6 July 2015

SF2012/024358
CR2015/002281
MJ

GOLDEN HIGHWAY (B84) & OTHER CLASSIFIED ROADS: DRAYTON MINE EXTENSION PROJECT (SSD 6875) – EXHIBITION OF ENVIRONMENTAL IMPACT ASSESSMENT

Figure 25: Road Network

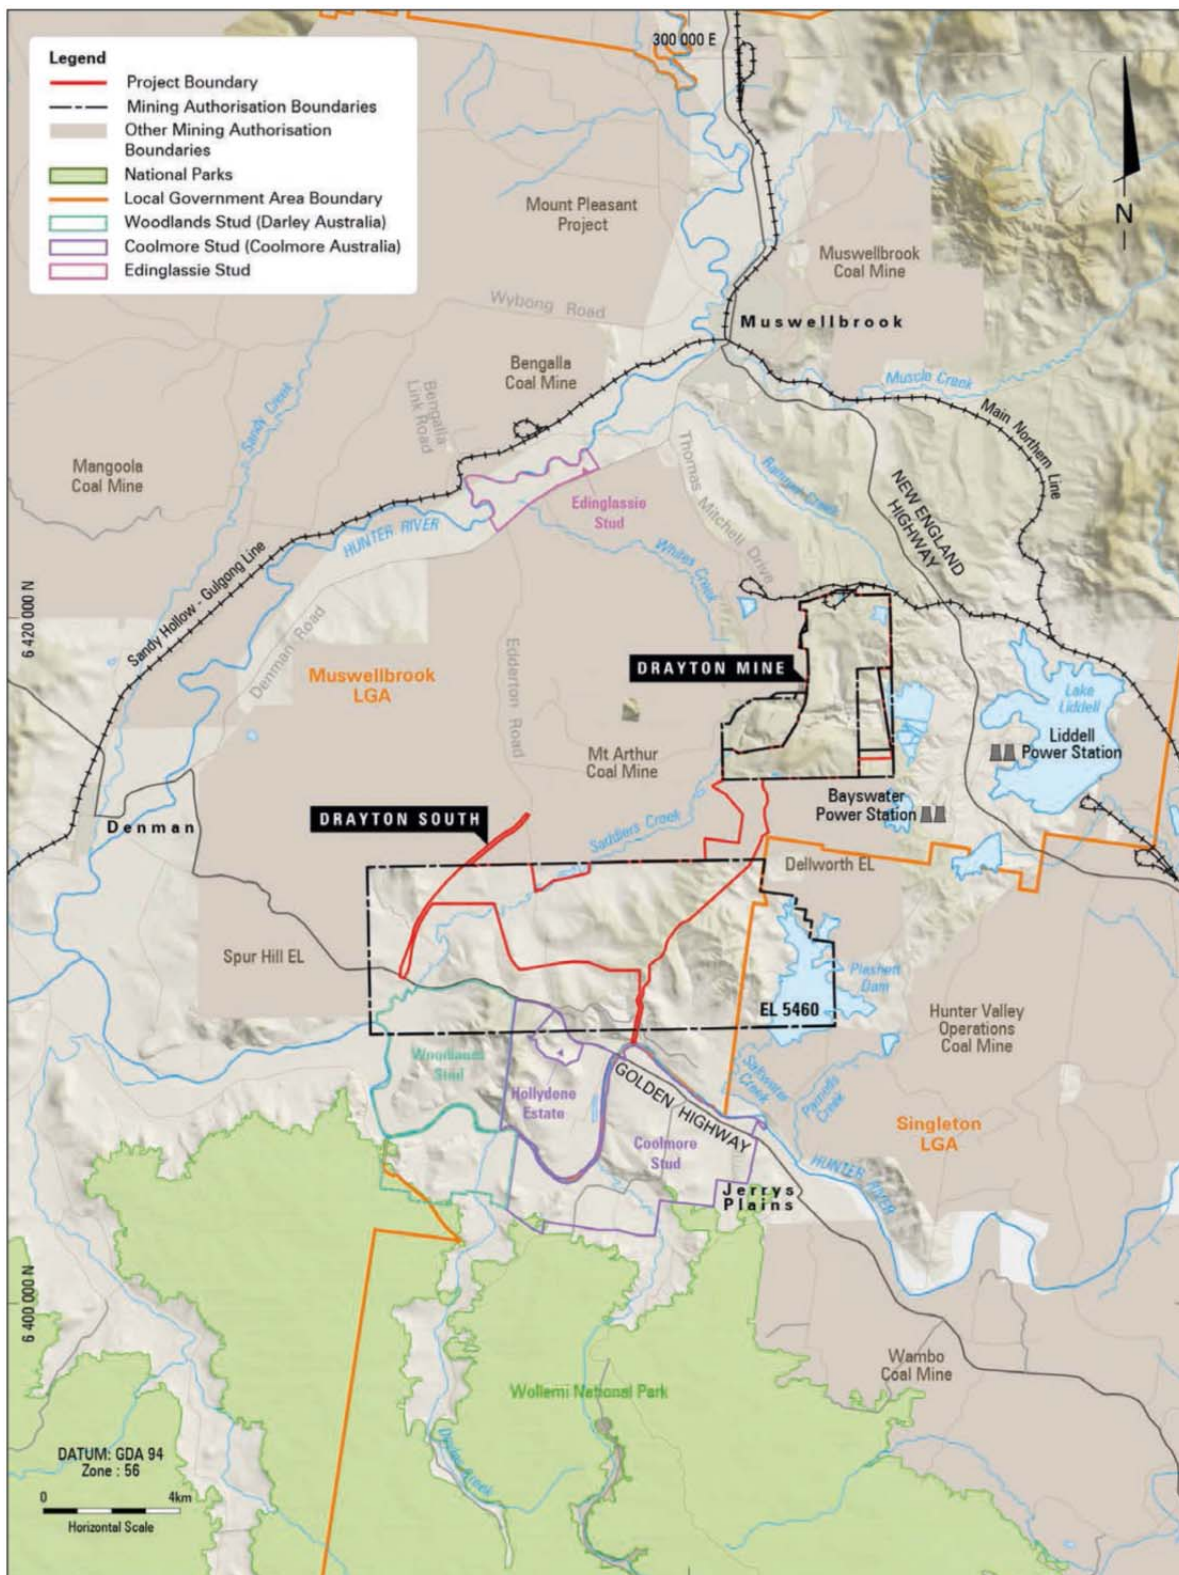
1. Prior to the commencement of construction activities and the mining operation associated with the proposed project the intersection of the Golden Highway (HW27) and Edderton Road shall be upgraded to a Type CHR / AUL intersection in accordance with Part 4A of the *Austrroads Guide to Road Design 2010* (with Roads and Maritime supplements), to the satisfaction of Roads and Maritime and Council. The following requirements will apply to the intersection:

- Edderton Road shall be aligned to intersect the Golden Highway at 90 degrees.
 - The intersection shall be designed to accommodate the turning path of the largest design vehicle.

- Provision shall be made at the intersection for on-road cyclists for the full scope of intersection works.
 - Street lighting shall be provided in accordance with Australian Standard AS1158, or as determined by RMS.

- Advanced intersection warning and all other road signs shall be provided on the Golden Highway, as determined by Roads and Maritime.

Comment: The Traffic and Transport Assessment report has focussed on traffic along Edderton Road and its connection with Denman Road. The report has not addressed existing and future traffic conditions at the Edderton Road / Golden Highway intersection, nor has it demonstrated the adequacy of the proposed intersection layout. A traffic analysis shall be undertaken and submitted in support of the detailed concept plans required for assessment under the Works Authorisation Deed (WAD) process. This report shall demonstrate the adequacy of the proposed intersection design in relation to traffic volumes, vehicle types and safe intersection sight distance on all legs of the intersection.

2. On relocation of the Golden Highway / Edderton Road intersection, the existing Edderton Road intersection shall be legally and physically closed to general traffic. Should the intersection be retained as an 'Emergency Access' to the mine site, then the access is to be gated and clearly signposted so as to indicate the nature of the access. The conditions for use of the access shall be captured in a 'Plan of Management' for the mine and any future change to the status of the access for general traffic shall be subject to further approval under a modification of the project approval and accompanied by a traffic impact statement clearly addressing related traffic conditions and any necessary intersection improvements.
